From: Simon Davis
Sent: 26 June 2018 12:53
To: Planning.Responses
Subject: FW: 59 Elm Grove, Barnham - EG/10/18/DOC

RE: EG/10/18/DOC

With regards to our position on Condition 6 relating to foul disposal for approved EG/41/17/PL, the applicant has stated on drainage proposals, drawing 2017/D1393/001, in note 12 construction of adoptable drainage in accordance with sewers for adoption standards.

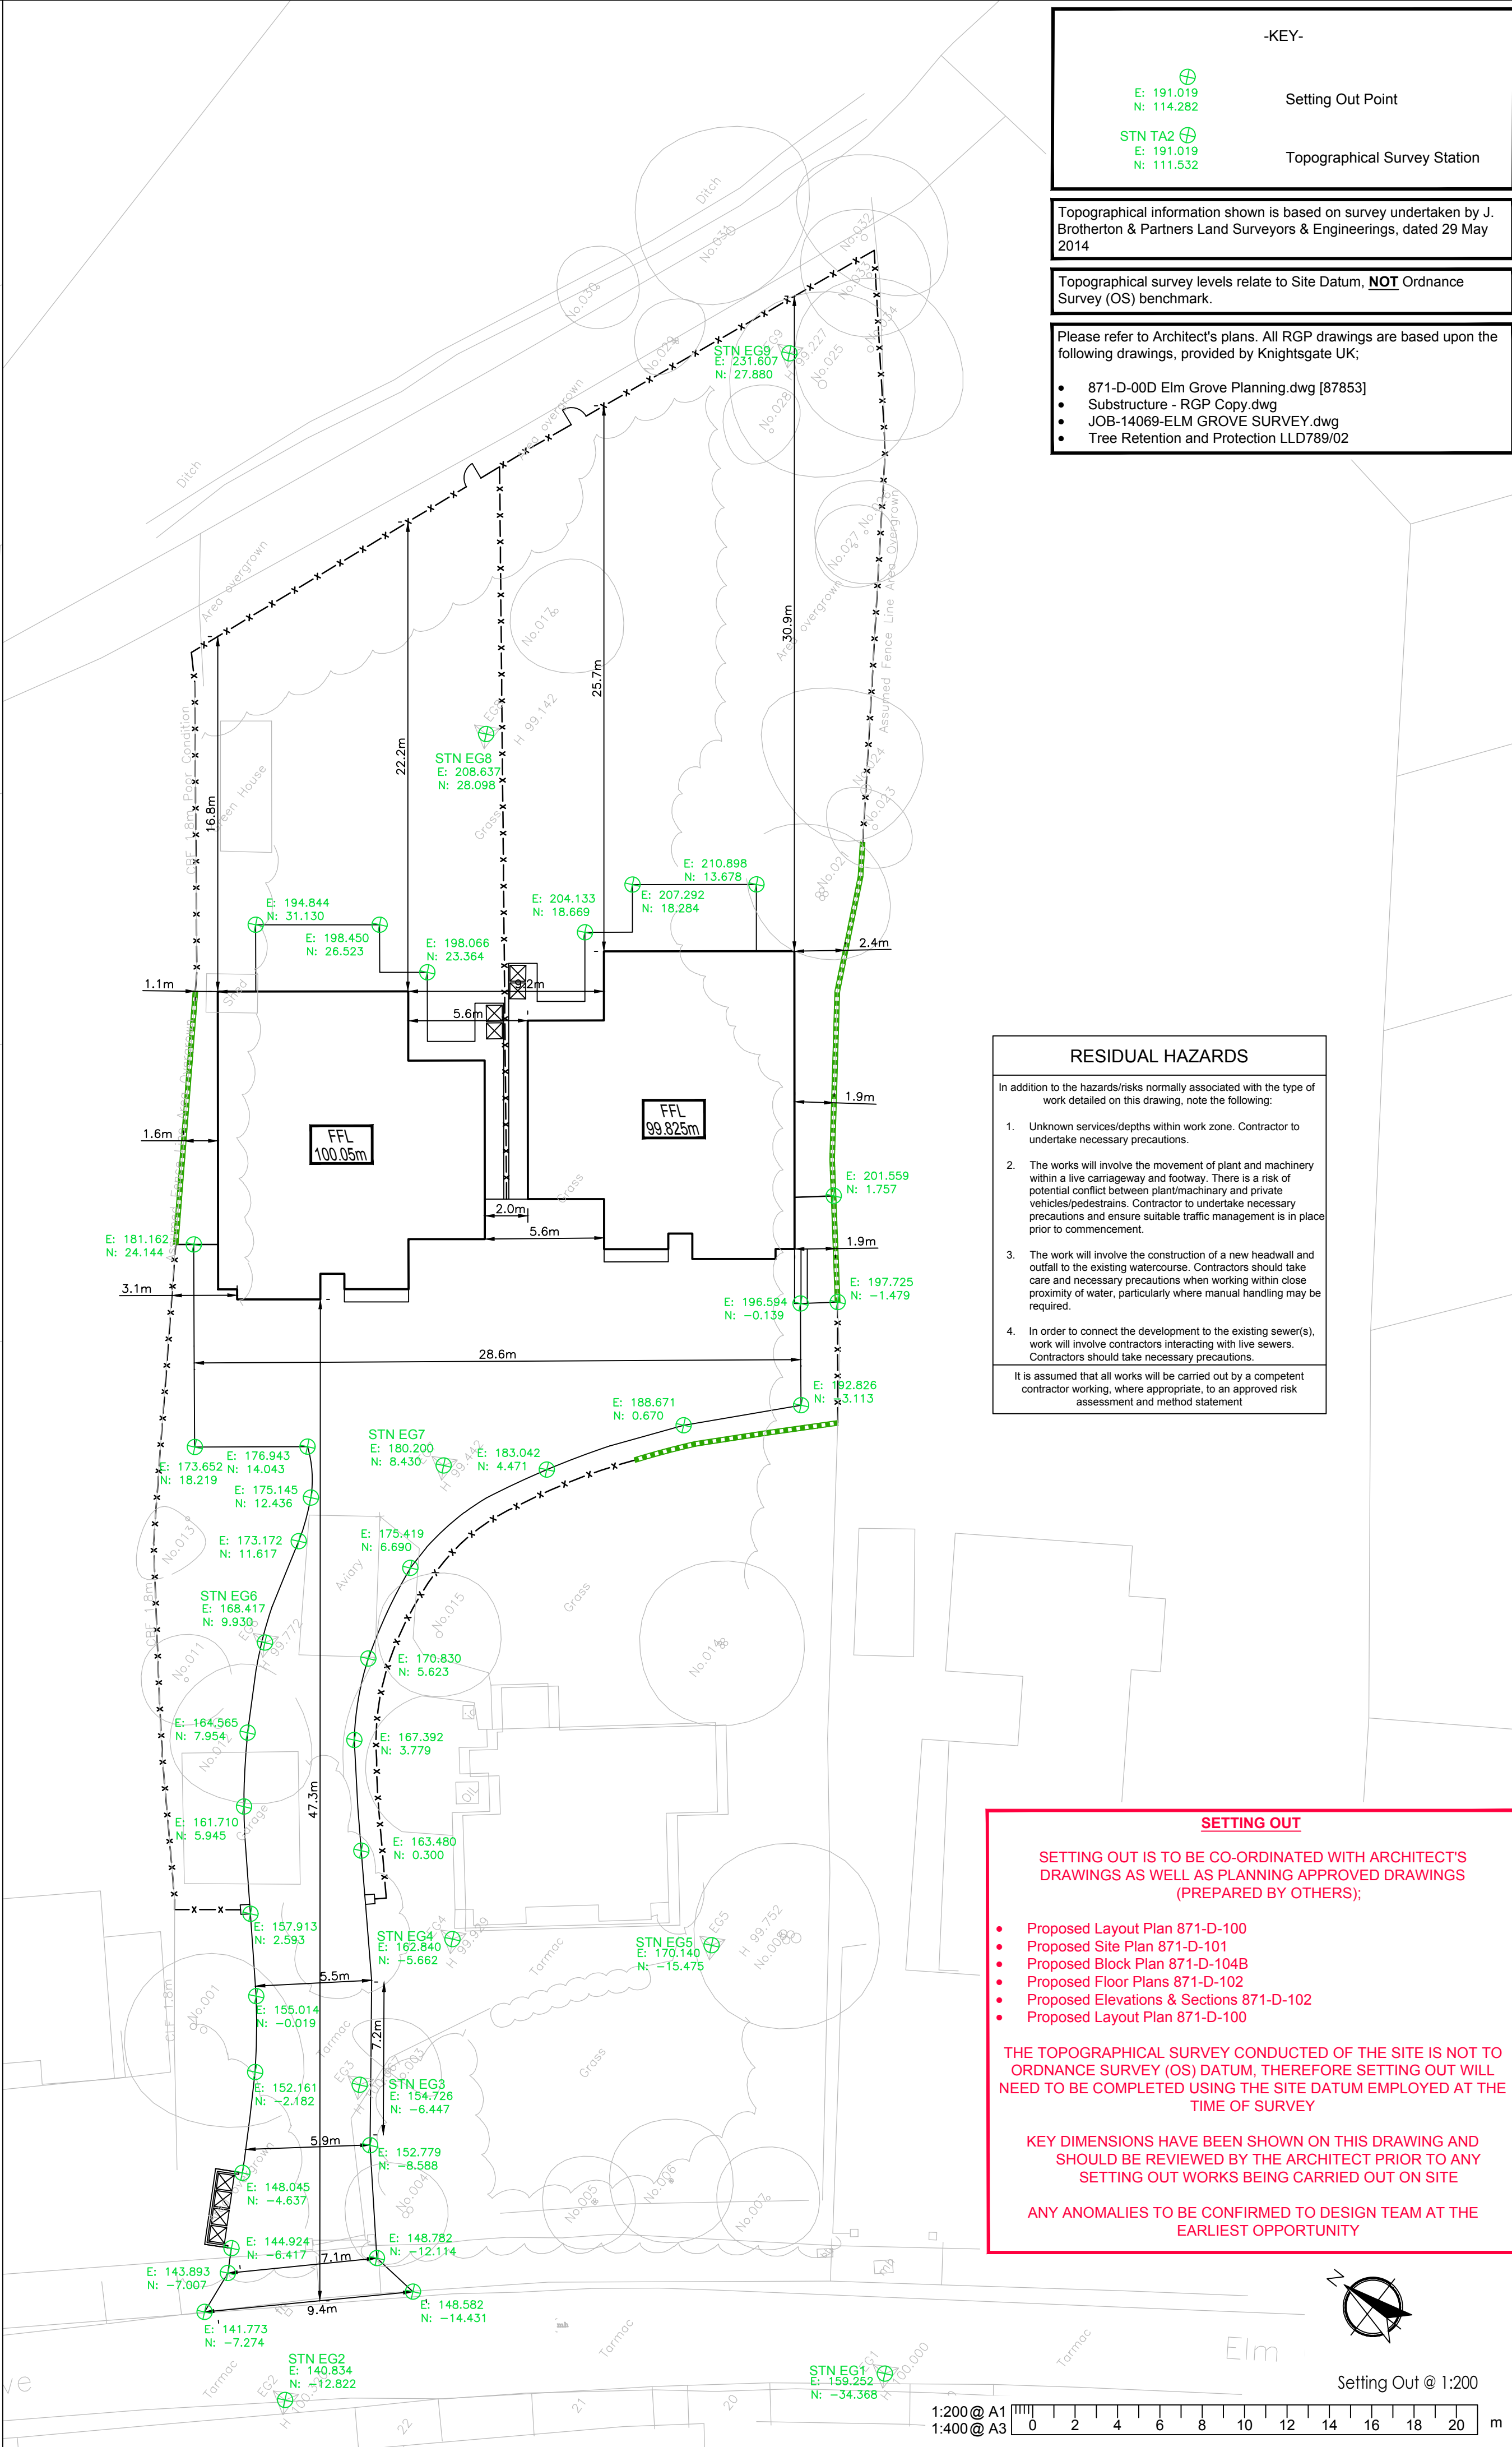
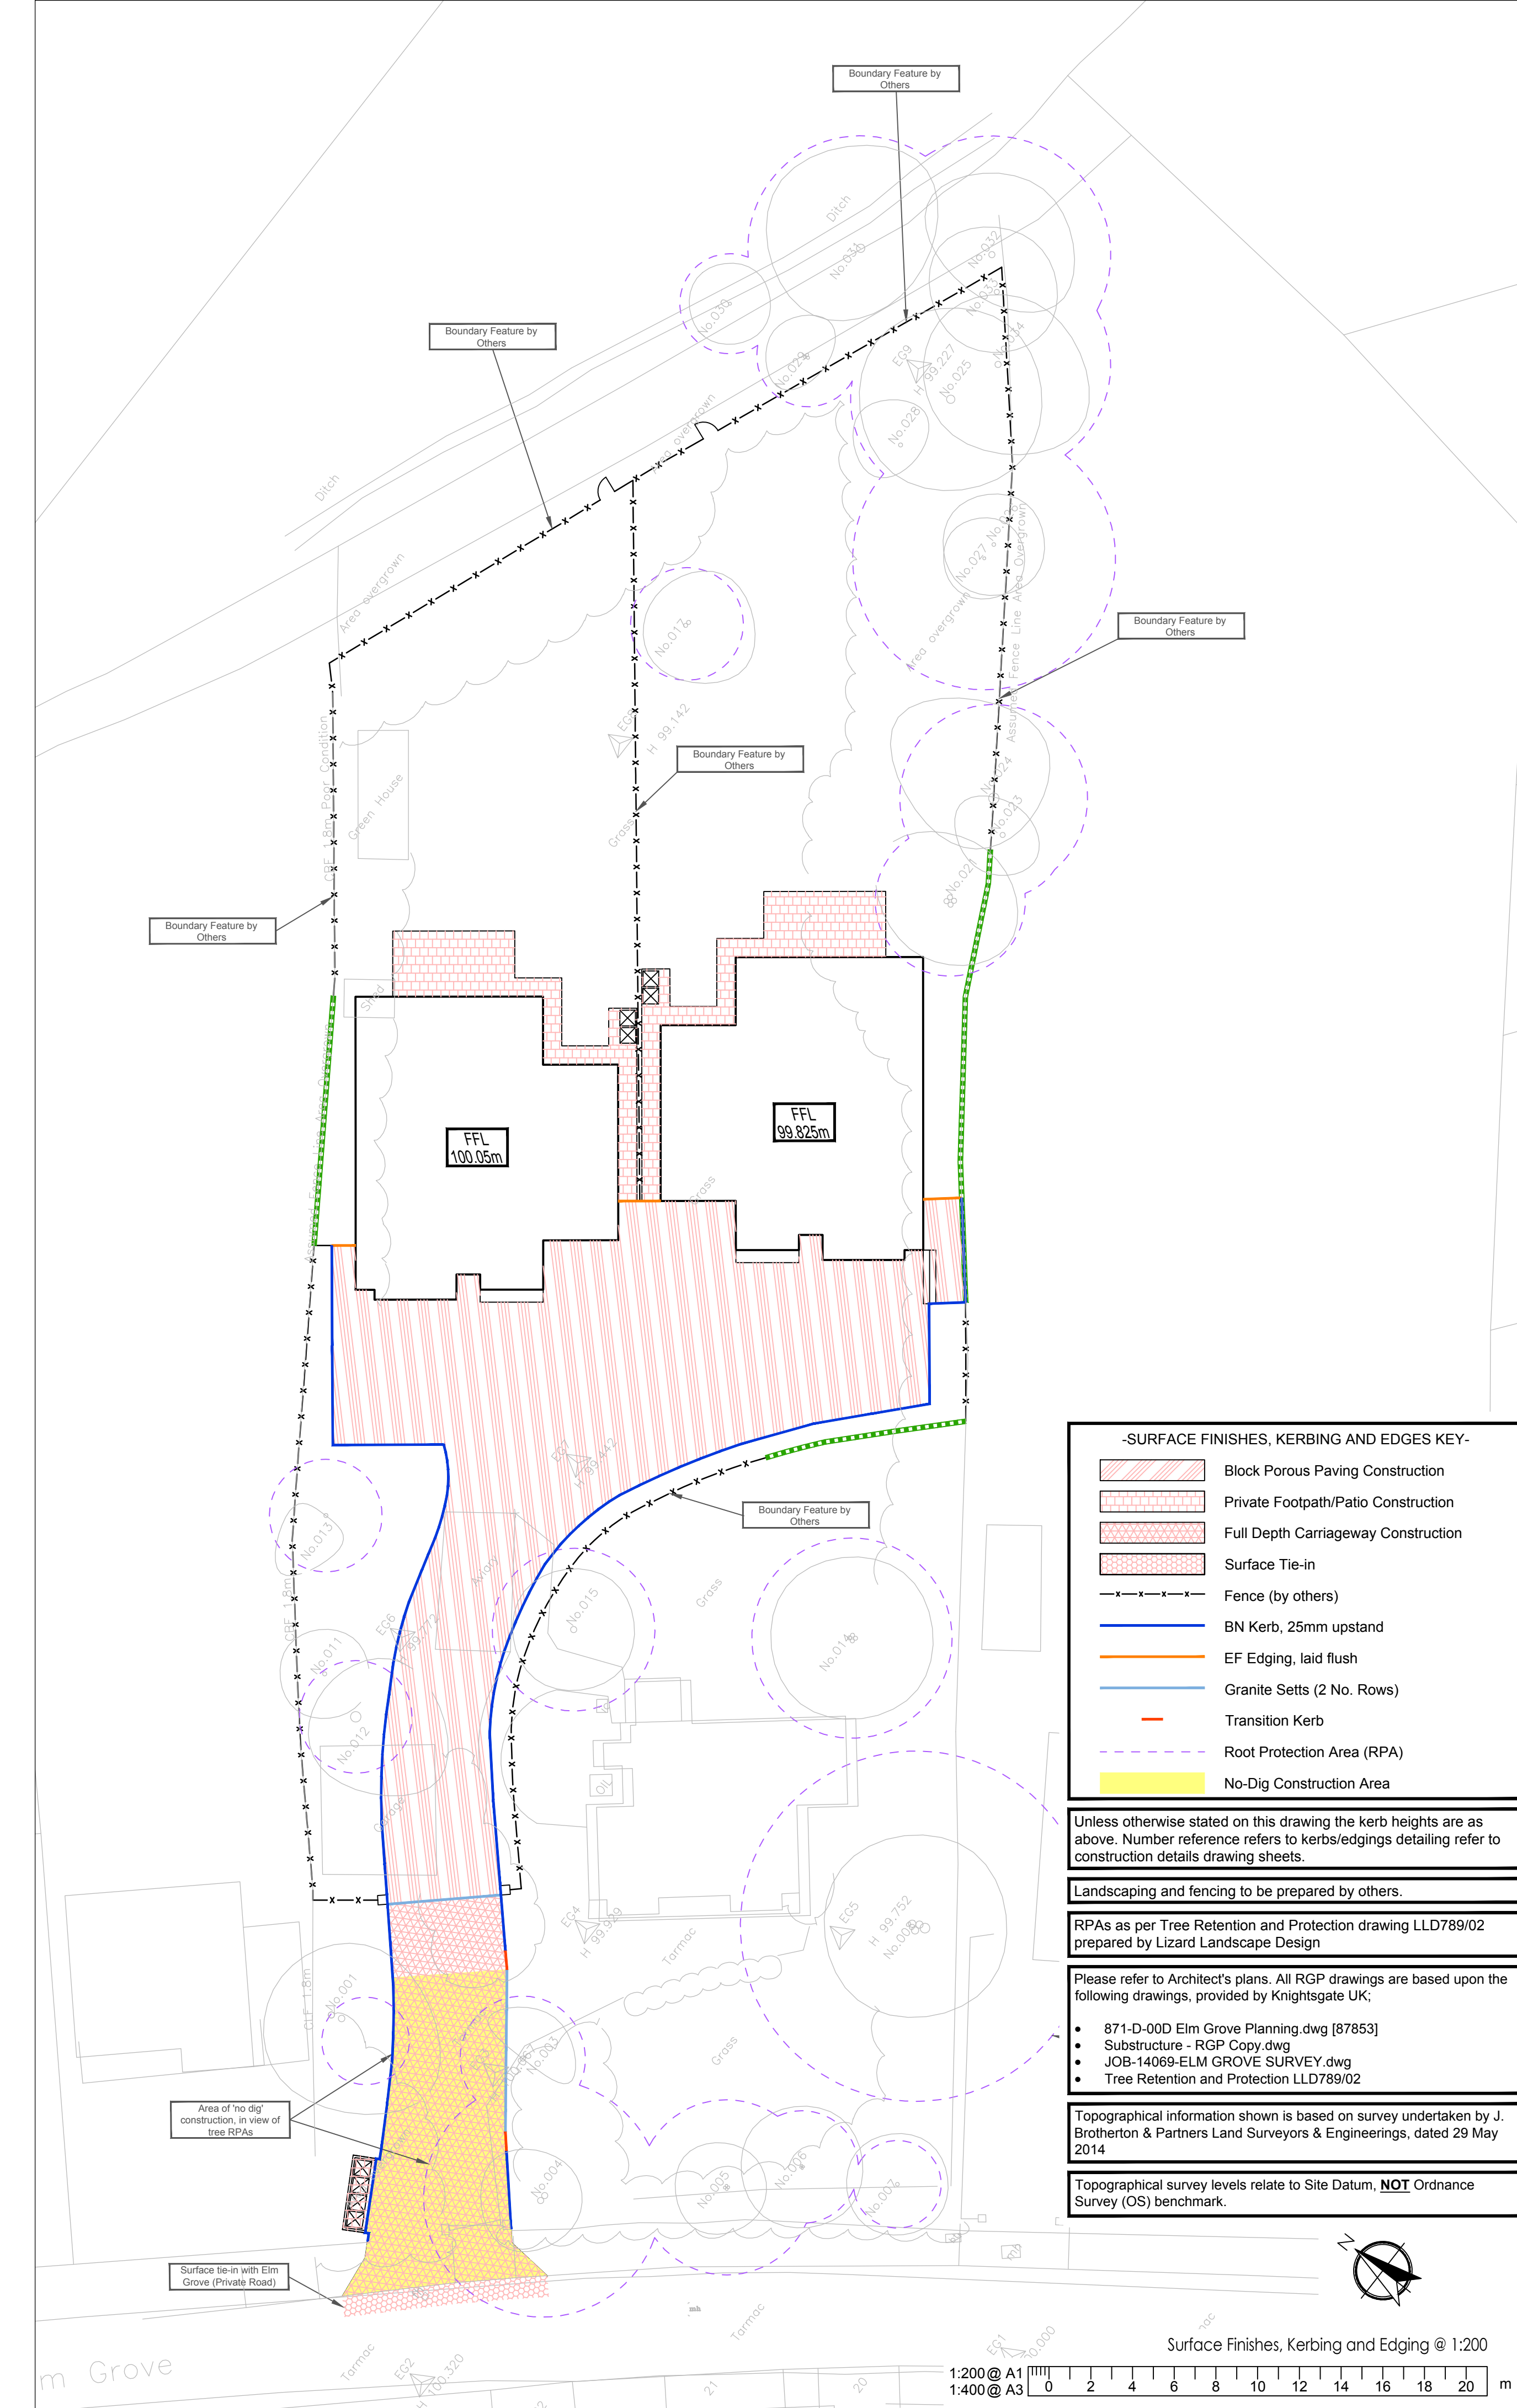
The design of the foul sewerage on site does not meet the standards that would be reasonably required by Southern Water and so consequently should the sewers be built as shown, Southern Water would not be prepared to enter into an agreement to adopt the sewers or accept them in the future under any change of government legislation. The developer has been made aware of Southern Water's stance and intends to source a maintenance company to main/repair the sewers within the site boundary.

Also the on site drainage design shall ensure that no surface water, groundwater or land drainage is to enter public foul sewerage network.

This is an ongoing issue with Southern Water although it is nothing to worry about – the sewers aren't being offered for adoption and will remain private so this can be ignored.
